**EL PASO COUNTY PLANNING AND
 COMMUNITY DEVELOPMENT
 DEPARTMENT**

GRADING AND EROSION CONTROL PLAN CHECKLIST

Revised: July 2019

File: C:\180031-Crossroads Mixed Use\Drawings\GR02.dwg PlotStamp: 11/23/2020 12:05 PM

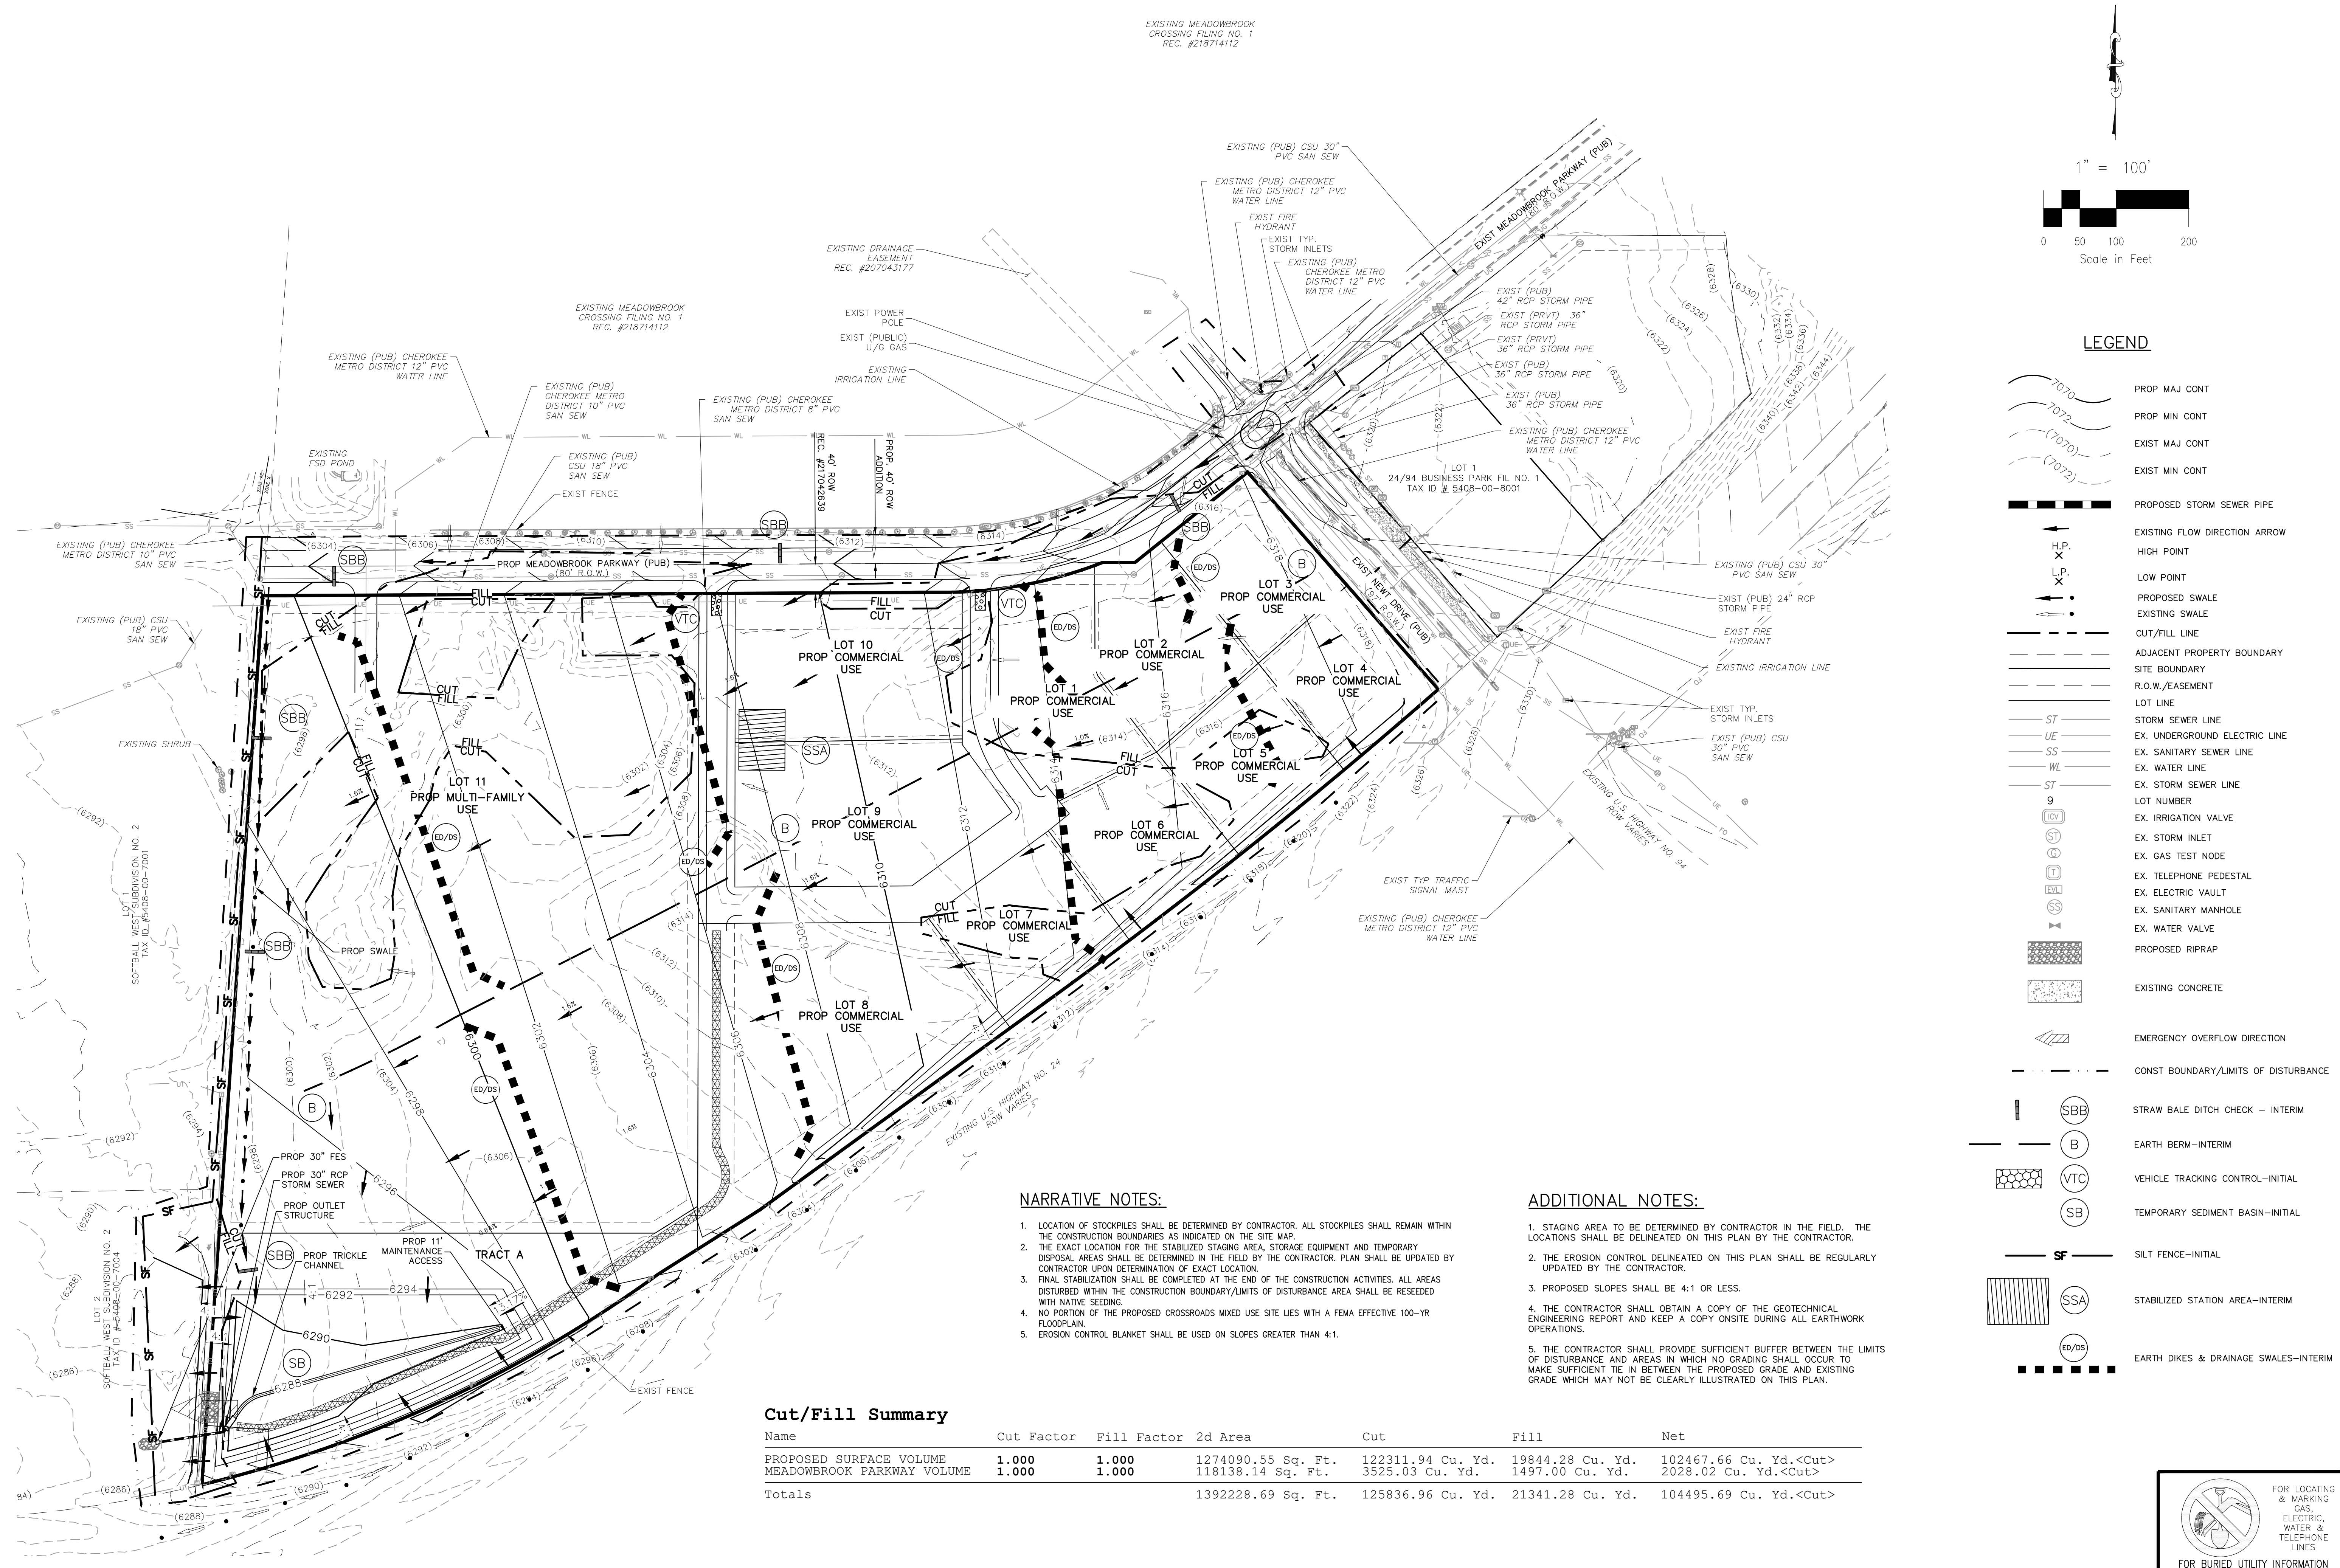
| | | Applicant | PCD |
|--|---|-----------|-----|
| i | Existing vegetation (notes are acceptable in cases where there is no notable vegetation, only grasses/weeds, or site has already been stripped). See comment on Sheet 2 of GEC Plans | ✓ | X |
